City of Albuquerque Stormwater Construction Site Inspection Report

General Information					
ESC File No.	H14E100	Project Name:	Agenda Global Warehouse		
NPDES Id. No.	NMRT0045X	Location:	1715 5th St NW		
6/13/2023	Owner		Contractor		
Operator	Agenda Real Estate Holdings, LLC		T2 Building LLC		
Contact name & title	Chris Taylor - Partner		Harold Stanley		
e-mail	ctaylor@agenda-global.com		hstanley@HDSTAN.com		
Contact Phone #	505-450-4703		803-8582		
COA Inspector	Chancellor English		Start/End Time:	3pm	
Construction Phase:	Construction				
Type of Inspection:	Regular	Storm Event	Post Storm Event >0.25"	311/Complaint	Follow Up
Weather at time of inspection?	Clear		Temperature: ~	80	
Estimated date of last storm 0.25" or greater	5/22/2023

ESC-3

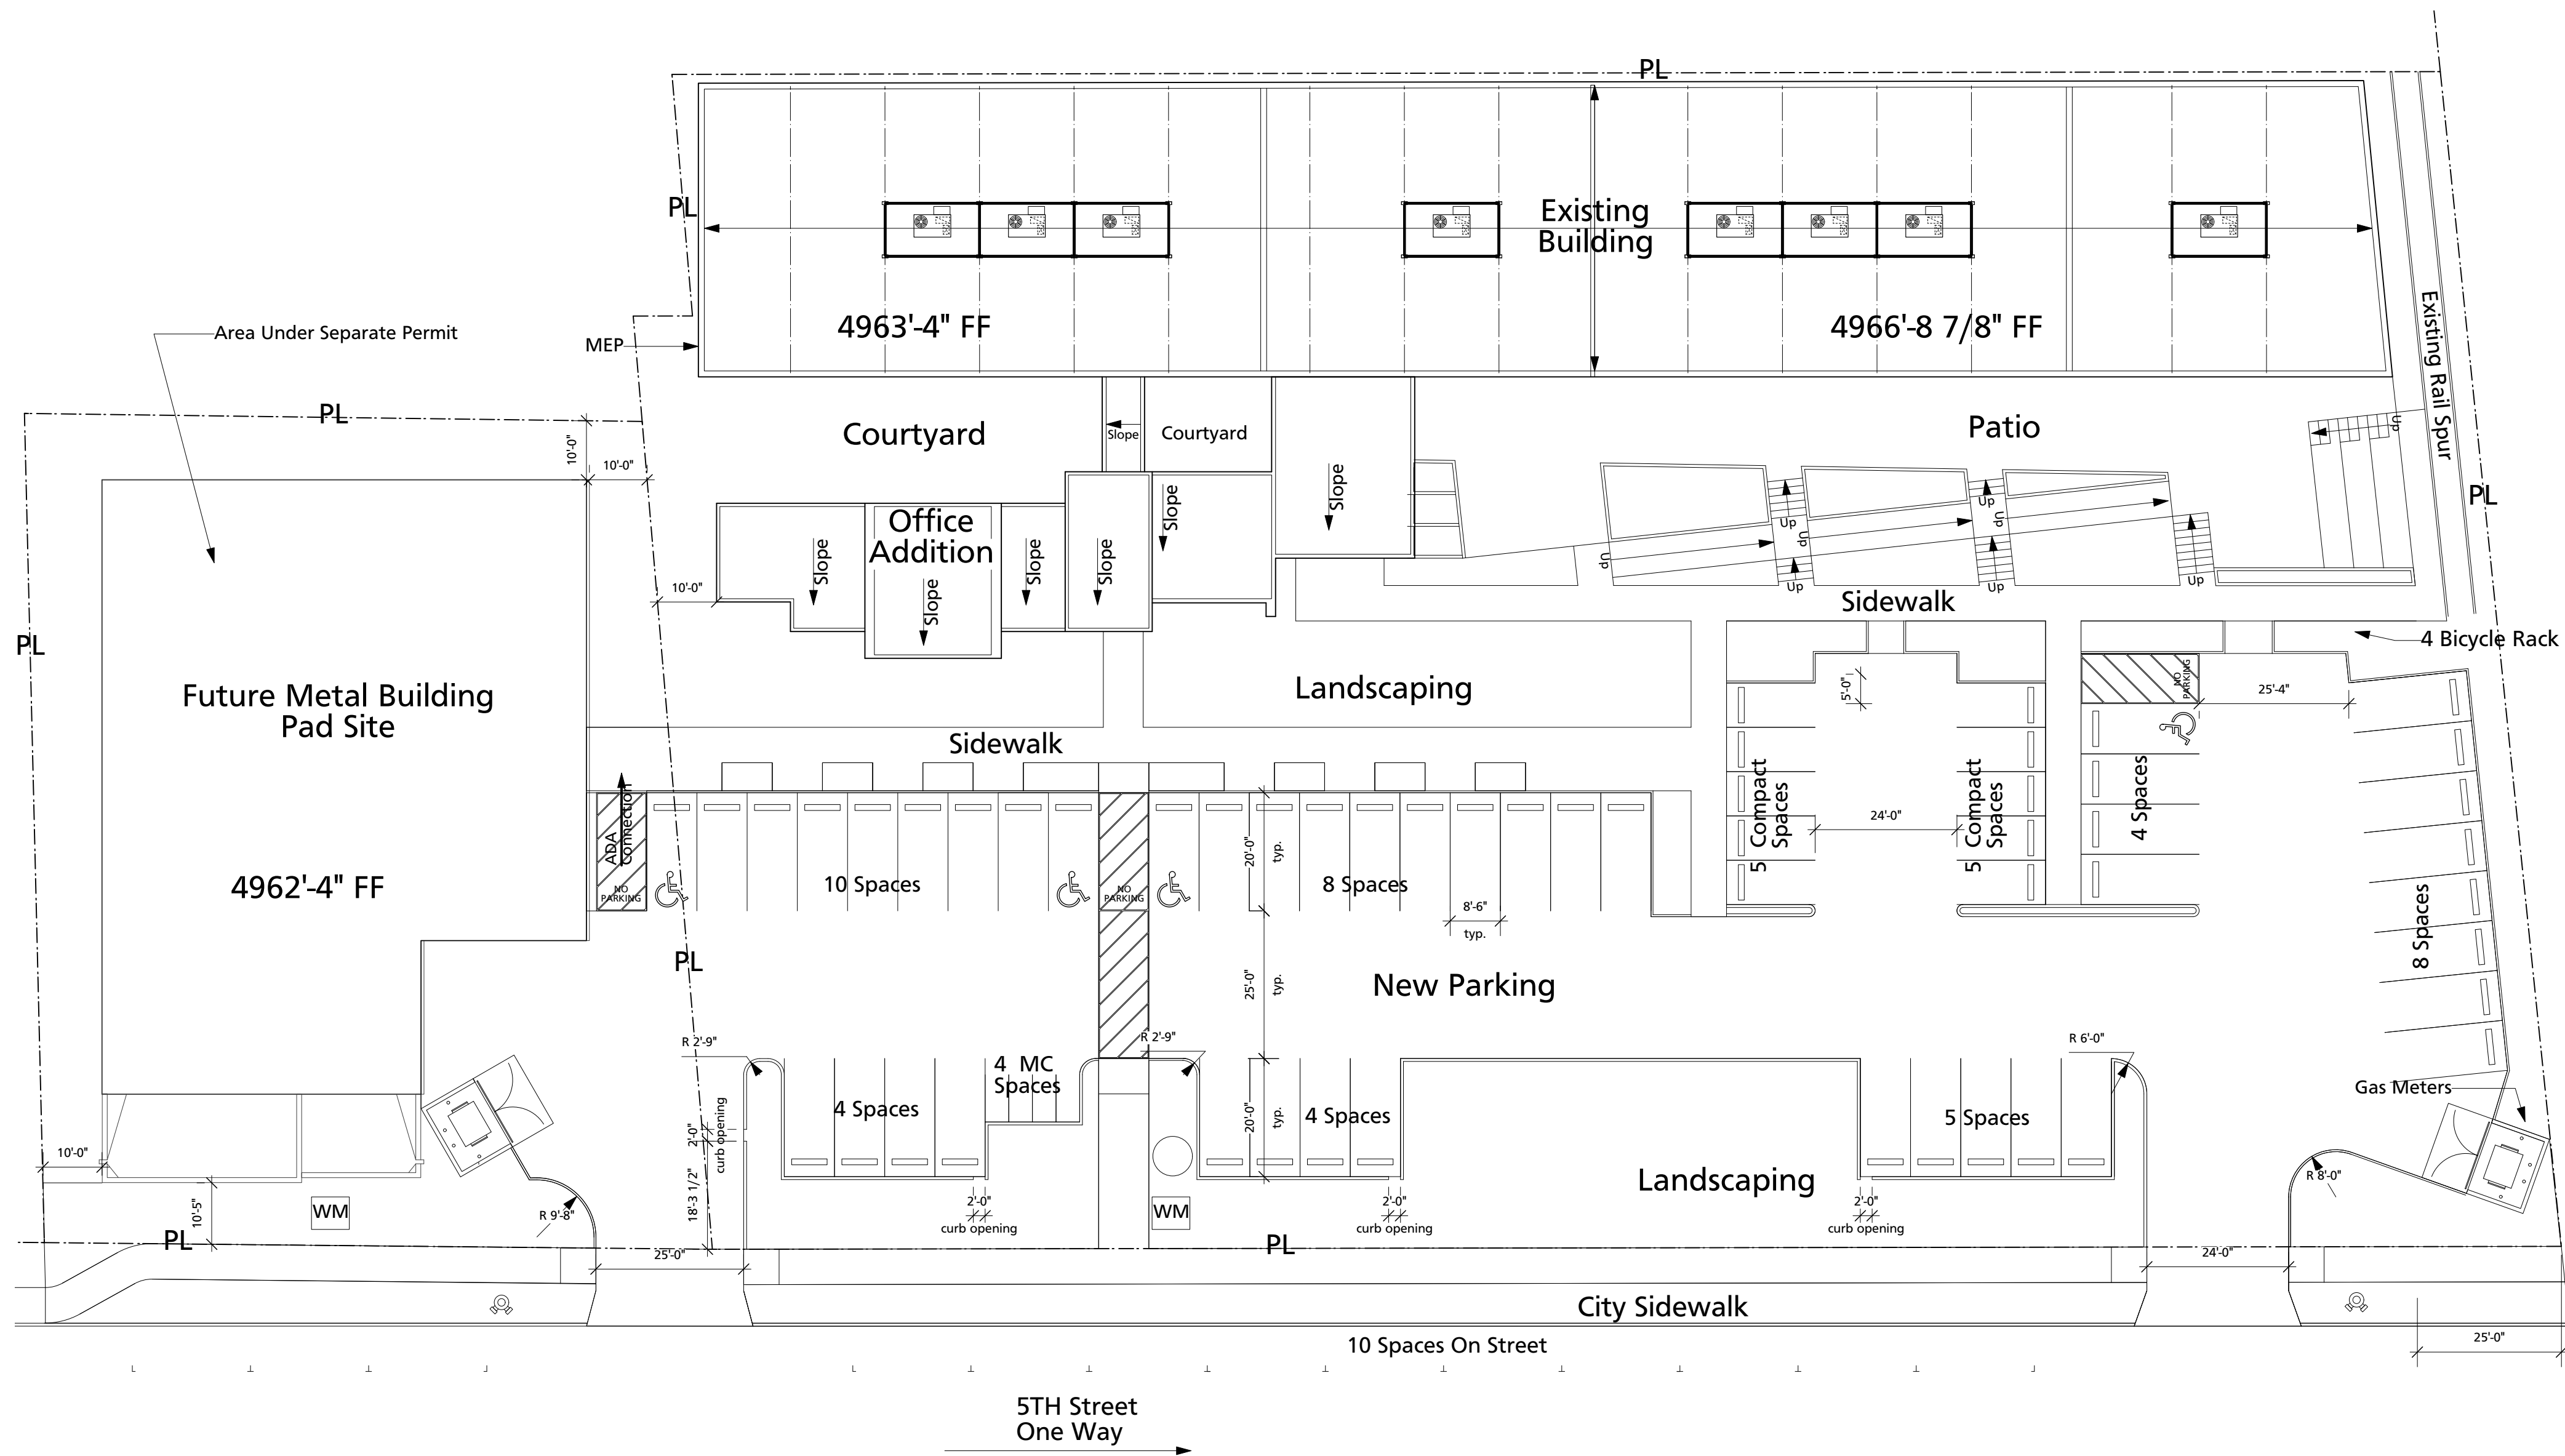
Item Number	Deficiency/ Corrective Action				
1	There were no BMPs installed at time of inspection. The ESC Plan shows a silt fence surrounding the perimeter. The CGP Section 2.1.4 states that you must ensure all stormwater controls are maintained and remain in effective operating condition during permit coverage.				
2	Washout was noted in several areas of the site, but no lined washout container. According to Section 2.3.4 of the CGP, you must direct wash water into a leak-proof container or leak-proof and lined pit; do not allow liquid wastes to be disposed of through infiltration or on the ground.				
3	The dumpster was not covered at the end of the work-day - contractors left during inspection. As per CGP Section 2.3.3.e, provide waste containers of sufficient size and number, and, for those without lids, provide a cover or similarly effective means designed to minimize the discharge of pollutants.
